Comment for planning application 23/00750/TEL56

Application Number	23/00750/TEL56
Location	Street Record Station Road Kirtlington
Proposal	Proposed telecommunications installation: Proposed 15.0m Phase 9 slimline Monopole and associated ancillary works
Case Officer	Gemma Magnuson
Organisation Name	Stephanie Hilborne
Address	Sunnyside, Troy Lane, Kirtlington, Kidlington, OX5 3HA
Type of Comment	Objection
Type	neighbour
Comments	<p>I am objecting to this planning application for a mast. I objected previously when an almost identical application was made and turned down at appeal. I suggest an officer visits the site to satisfy themselves as to the blatant inaccuracy of many of the statements in the application. I regard this application as cynical as was the original which deliberately split the application from the base from the main mast.</p> <p>Clearly since local residents have full lives, our ability to repeatedly respond and set out the reasons against this application is limited. The number of objections may be small as a result of this deliberate process of wearing us out. I run a charity and am caring for an elderly mother and spare time is precious.</p> <p>The other reason

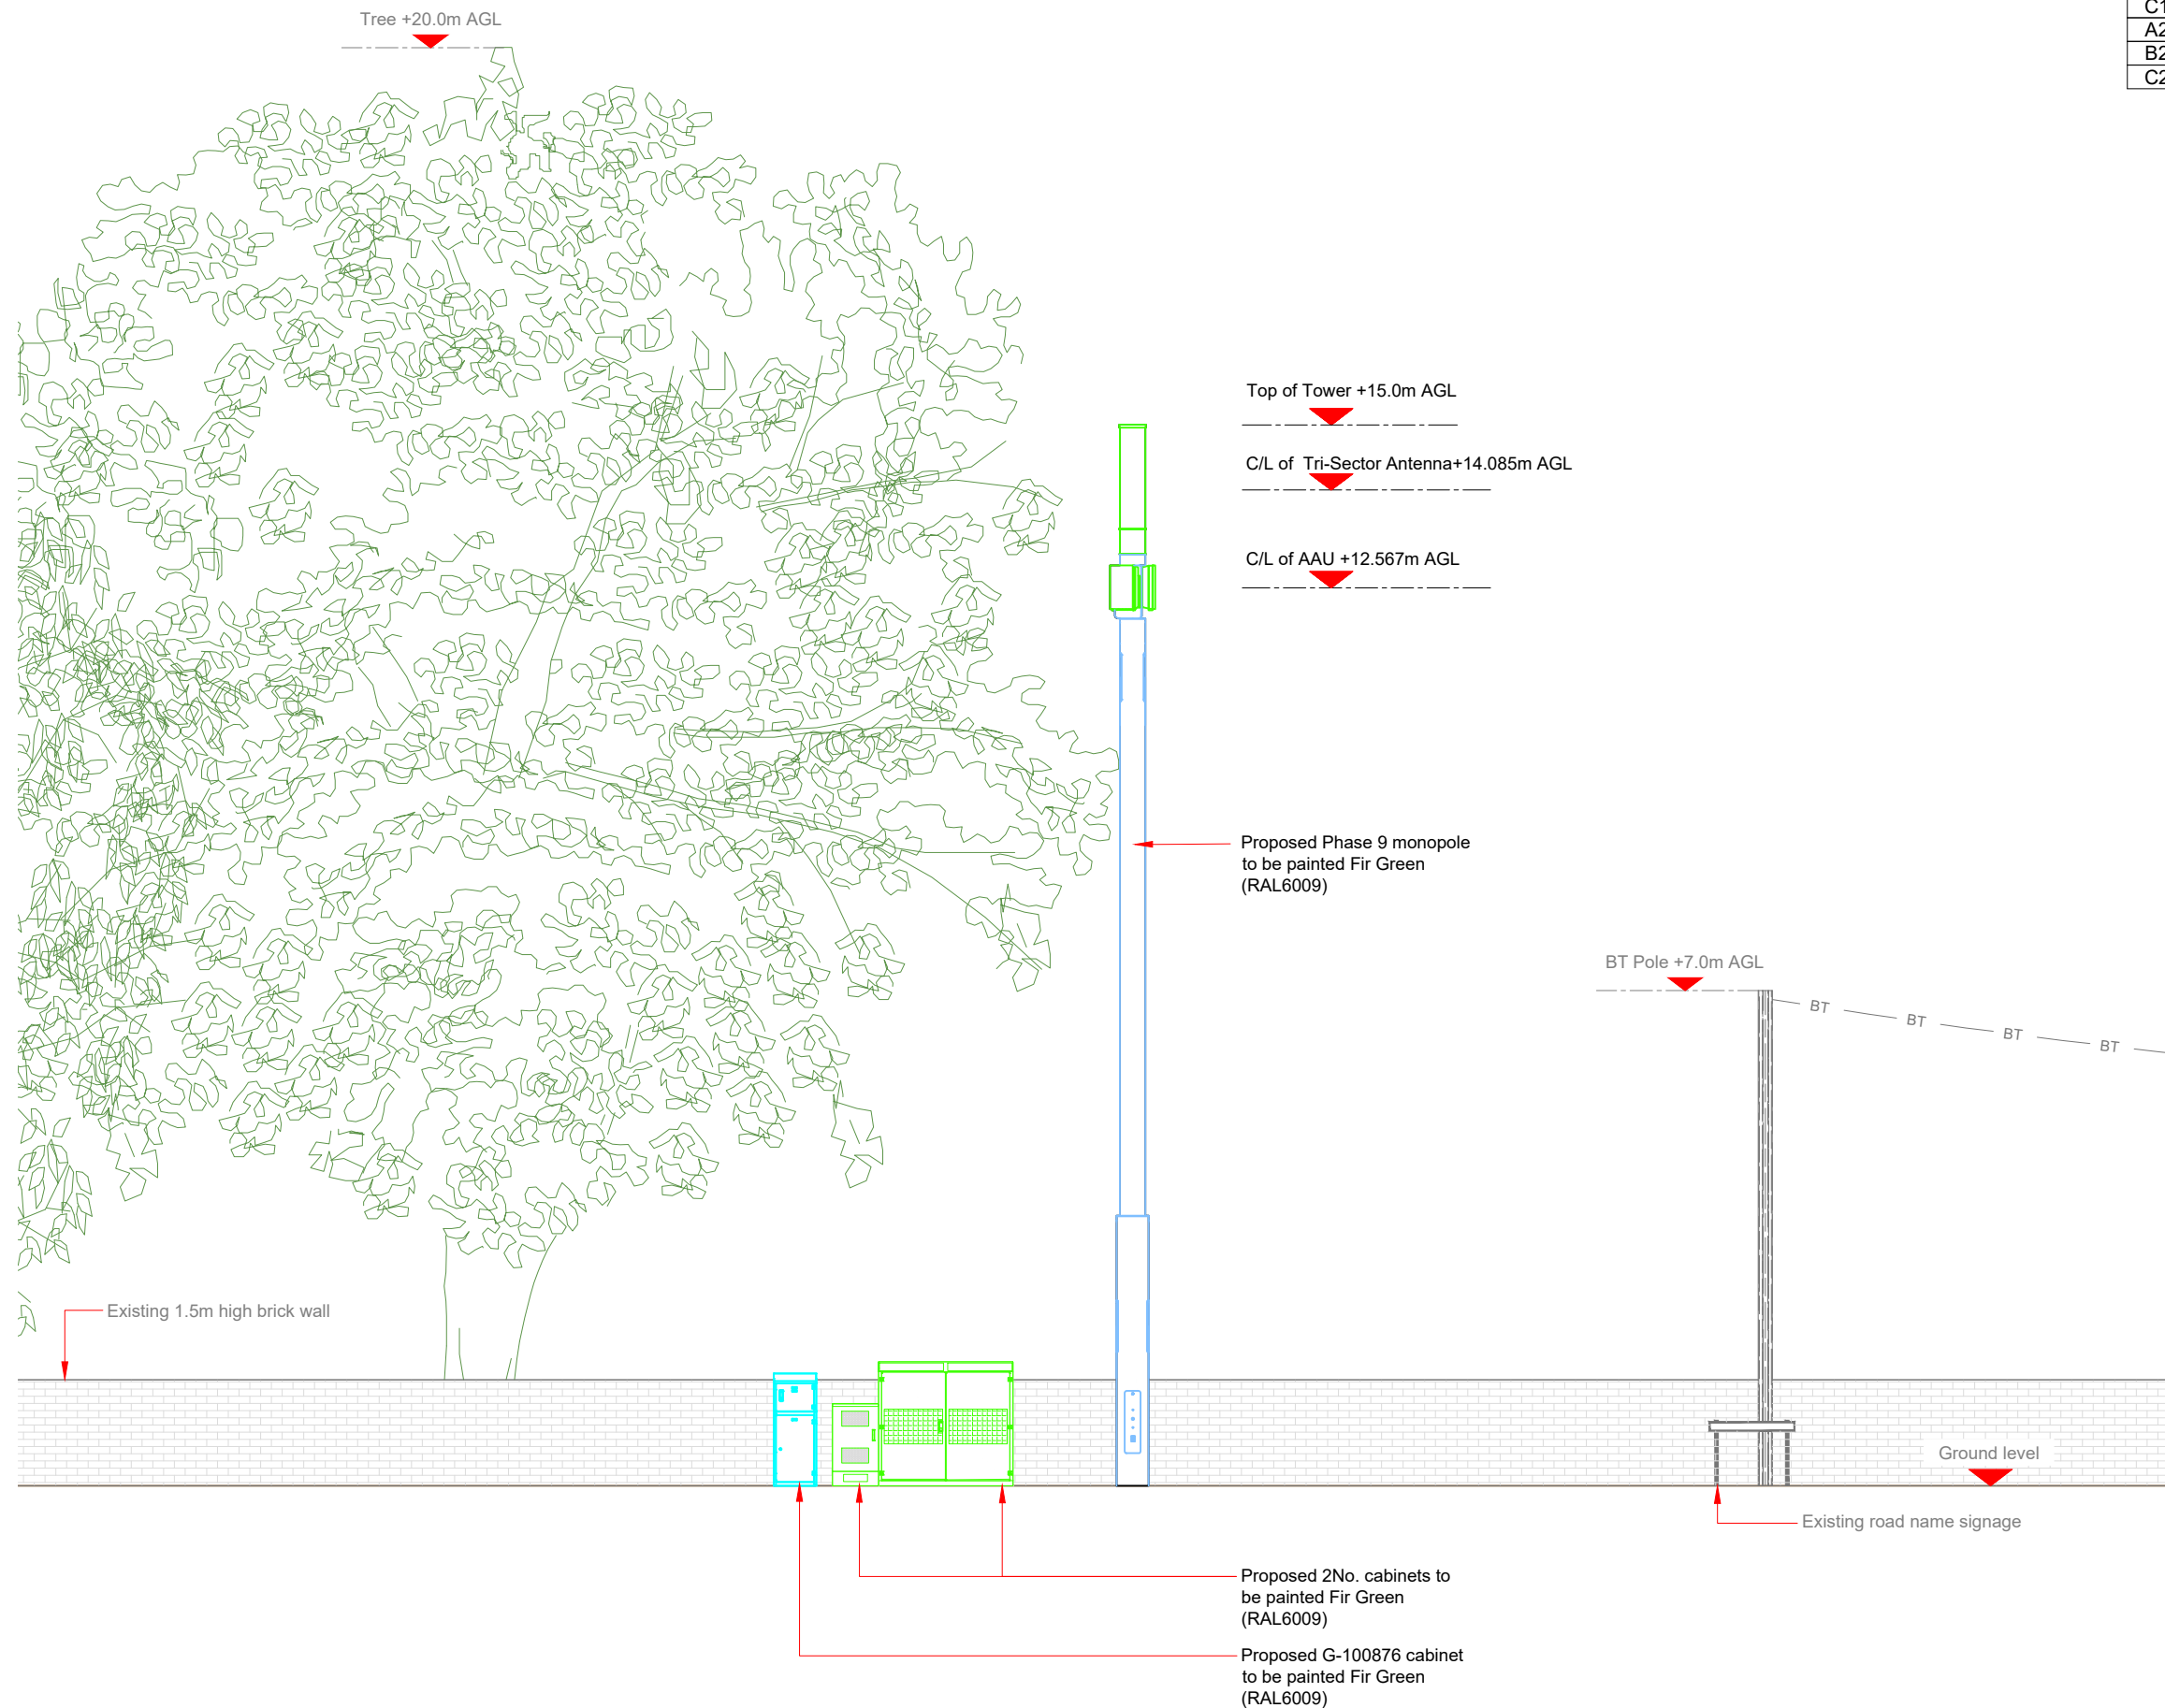
This is a cynical planning application, in its plan drawings (of existing and proposed) including lack of details both in what the mast will look like bar a misleading drawing against a tree (which is only from one angle), and photography that shows very little of the actual area - including NONE of the surrounding houses who will be in direct line of the mast.

Figure 5:

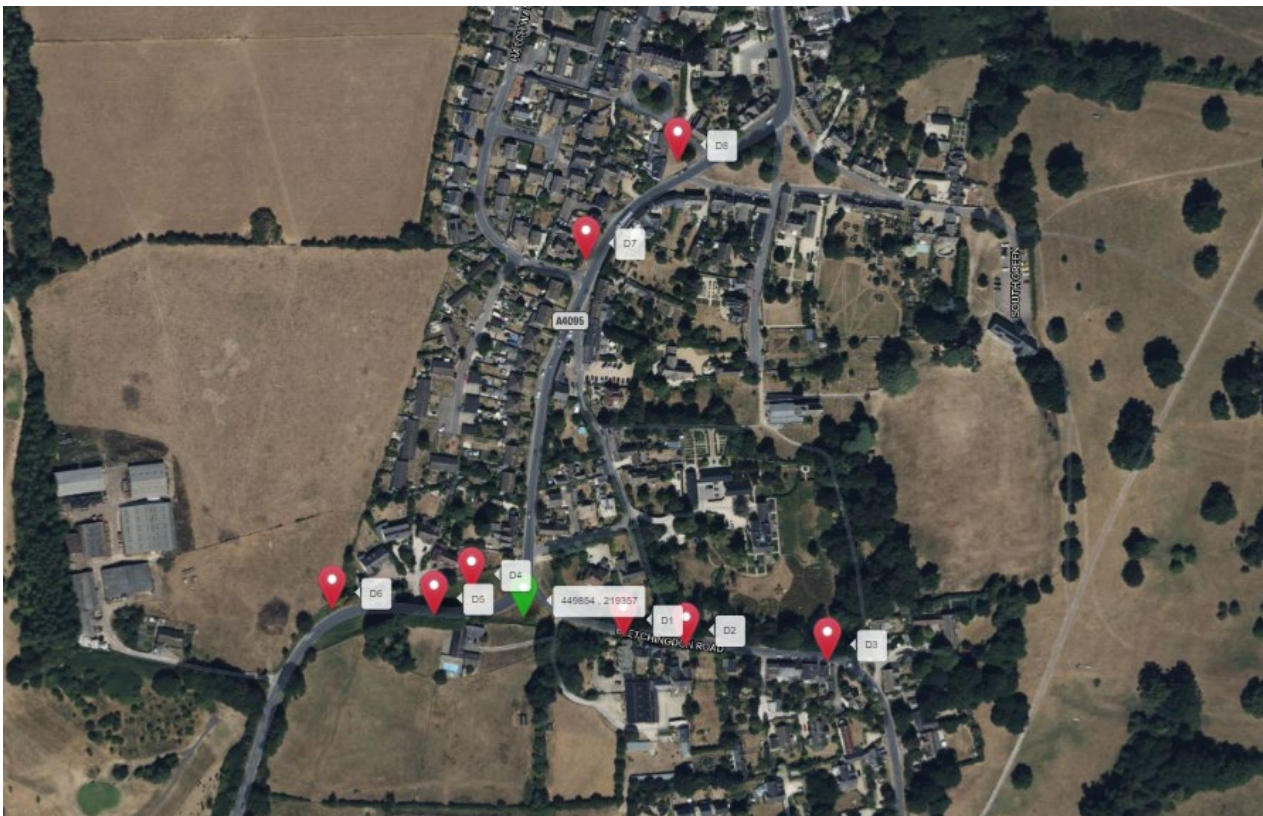
If you look at these and the map, they are all listed as : "highly visible from onlooking residential properties" INCLUDING the site they are proposing:
"D4 - 449819 , 219374, Grass verge adjacent to Oxford Road discounted due to lack of screening. Site is highly visible from onlooking residential properties."

They have said themselves this site should be discounted! (see attached and photograph on application).
